RE: Caddis Creek Short Plat, File Number SP-07-45

MEMORANDUM

TO: Mike Elkins, Community Development Services
FROM: Christina Wollman, Planner II *cw*
DATE: June 12, 2007
SUBJECT: Caddis Creek Short Plat

Subject: SP-07-45, Caddis Creek Short Plat (3 Lots); Parcel #20-14-18040-0014
Tony Schumacher, landowner/Encompass Engineering, authorized agent
Access Via I-90 Exit 74 (W. Nelson Siding Road)

CADDIS CREEK SHORT PLAT

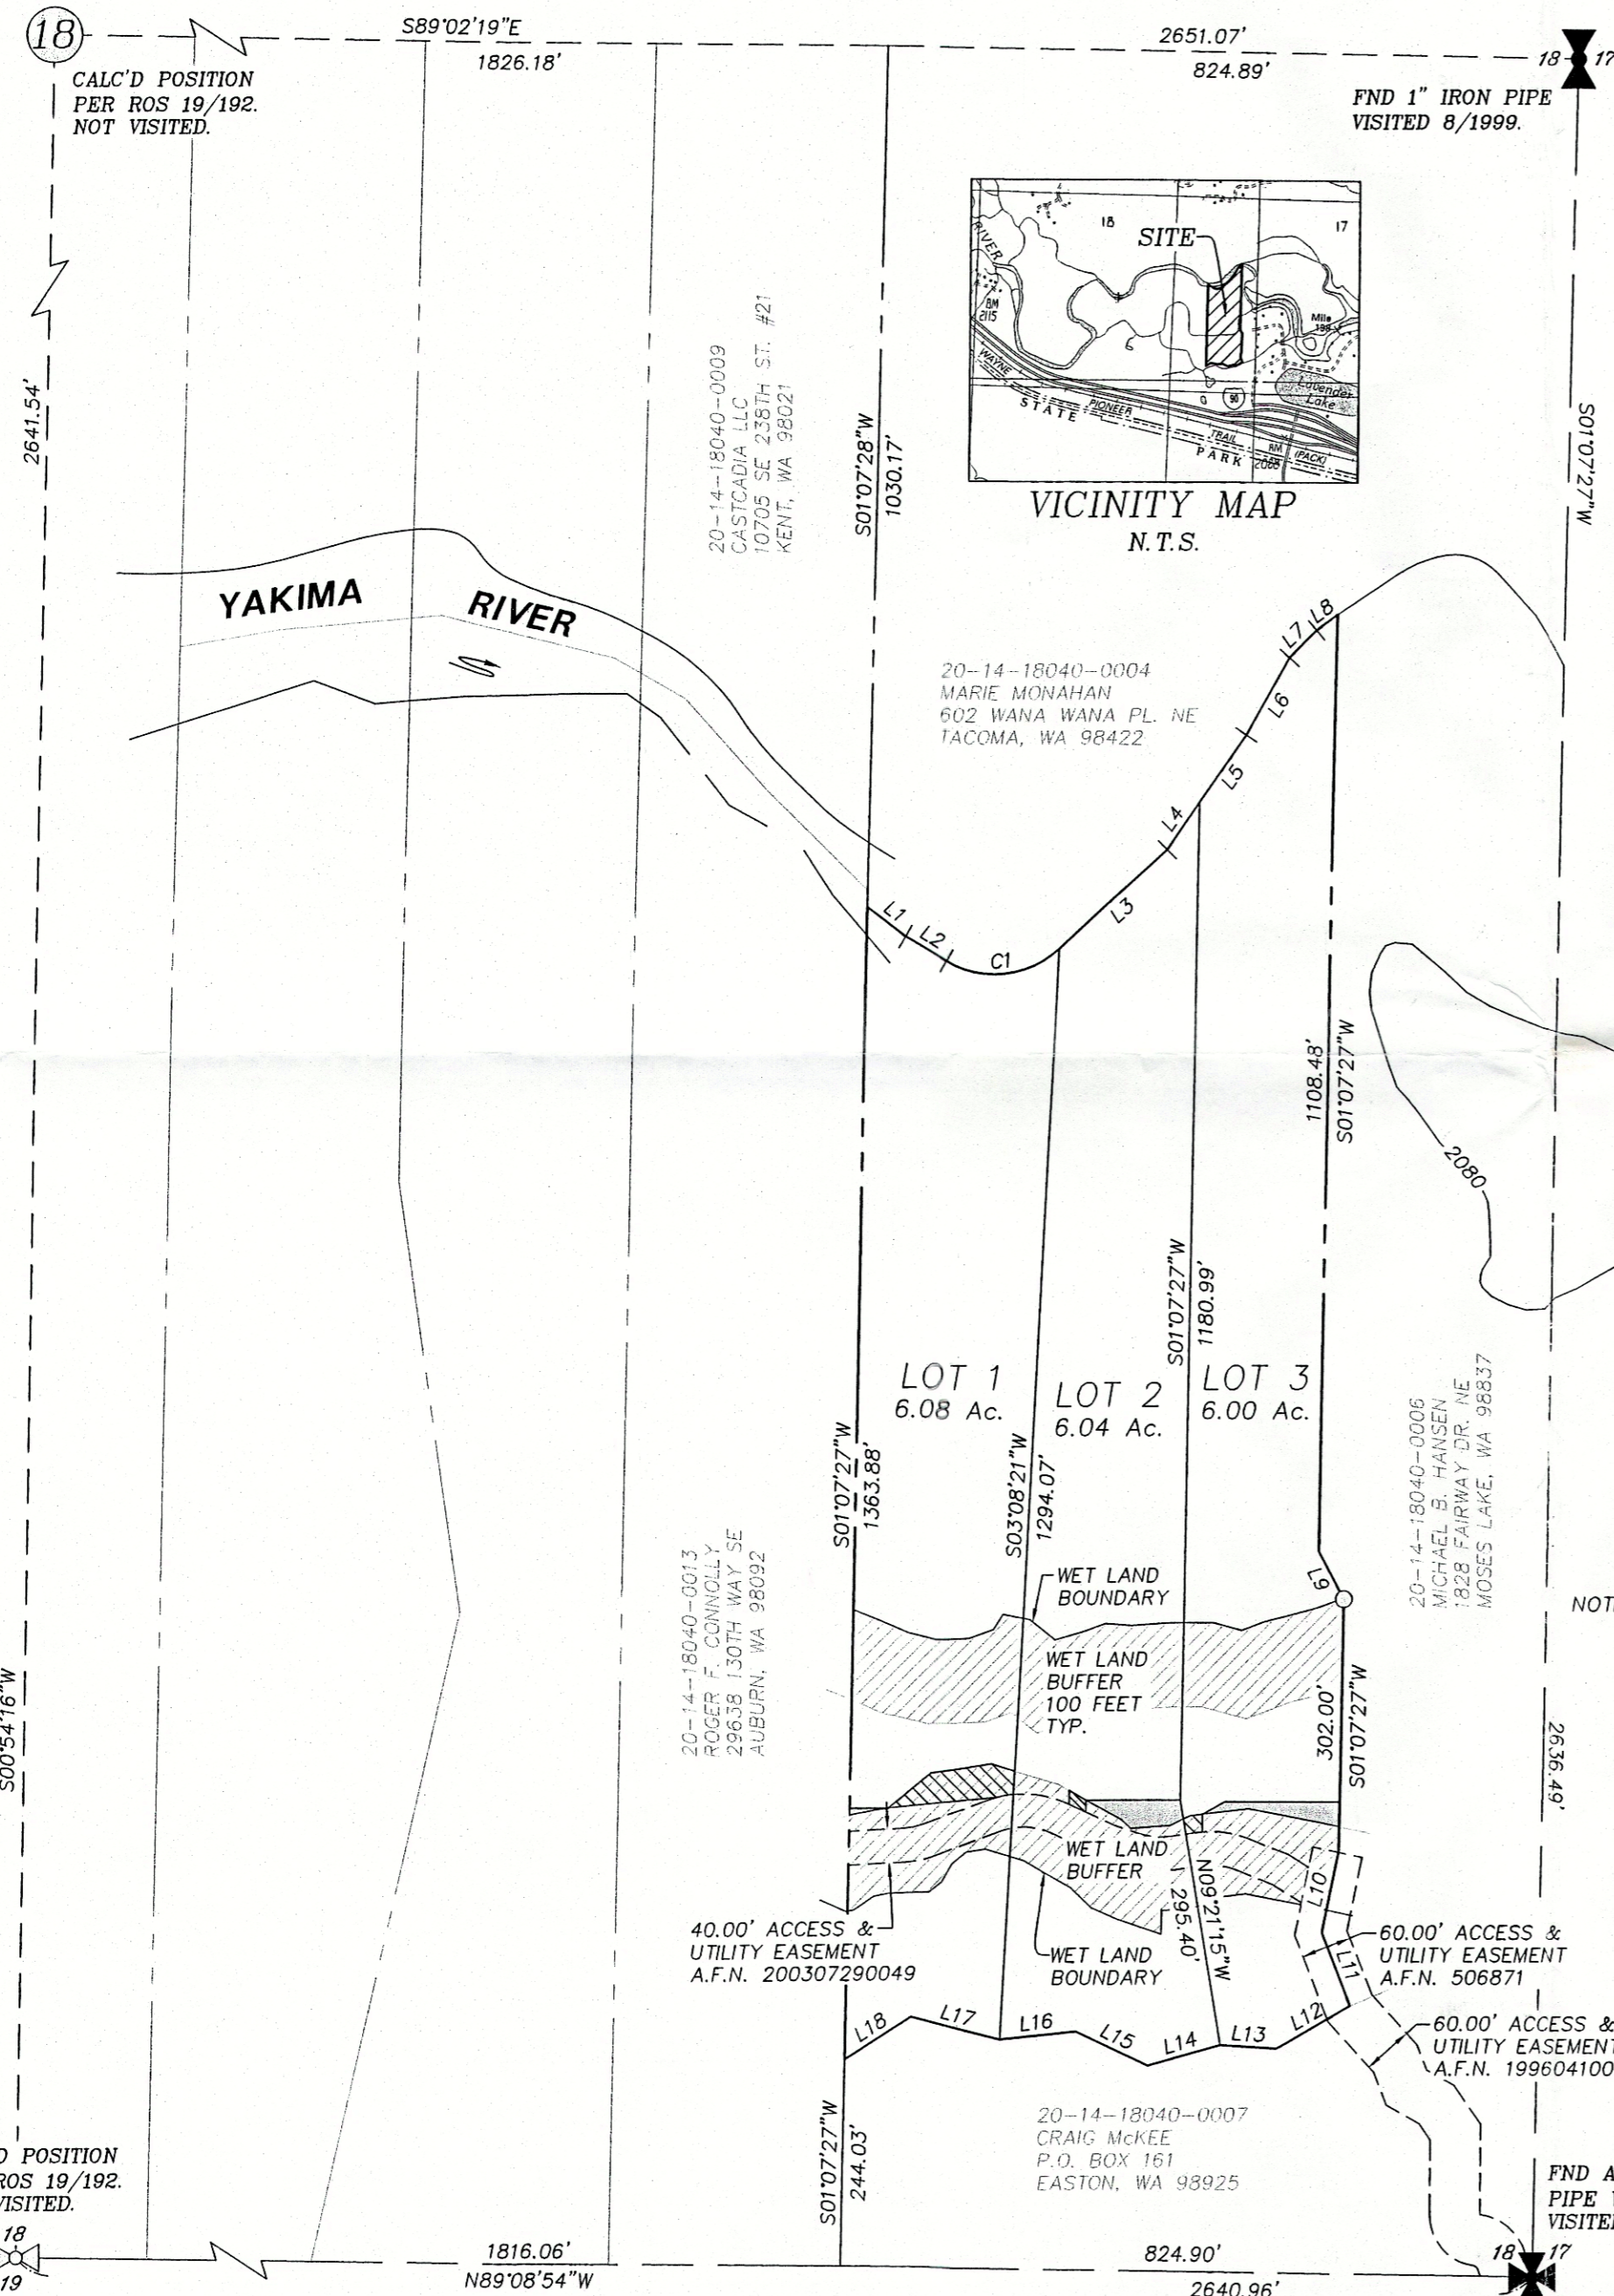
Pine Glen Drive currently serves more than 40 lots. Per Kittitas County Road Standards 12.01.095(2), a second access is required for all roads serving more than 40 lots. The second access shall be identified prior to conditional approval.

Additionally, The Caddis Creek Short Plat is accessed from Lavender Road, a Washington State Department of Transportation owned and maintained road. WSDOT has stated that as condition of approval, Lavender Road shall be brought up to Kittitas County Road Standards and added to the County road system.

1. The plat site is adjacent to Interstate 90. I-90 is a fully-controlled limited access facility with a posted speed limit of 70 miles per hour. No direct access will be allowed to I-90.

Water Source is not indicated. In Washington State, prospective water users must obtain authorization from the Department of Ecology before diverting surface water or withdrawing ground water, with one exception. Ground water withdrawals of up to 5,000 gallons per day used for single or group domestic supply, industrial purposes, stock watering or for the irrigation of up to one-half acre of lawn and garden are exempt from the permitting process. Water use under the RCW 90.44.050 exemption establishes a water right that is subject to the same privileges, restrictions, laws and regulations as a water right permit or certificate obtained directly from Ecology.
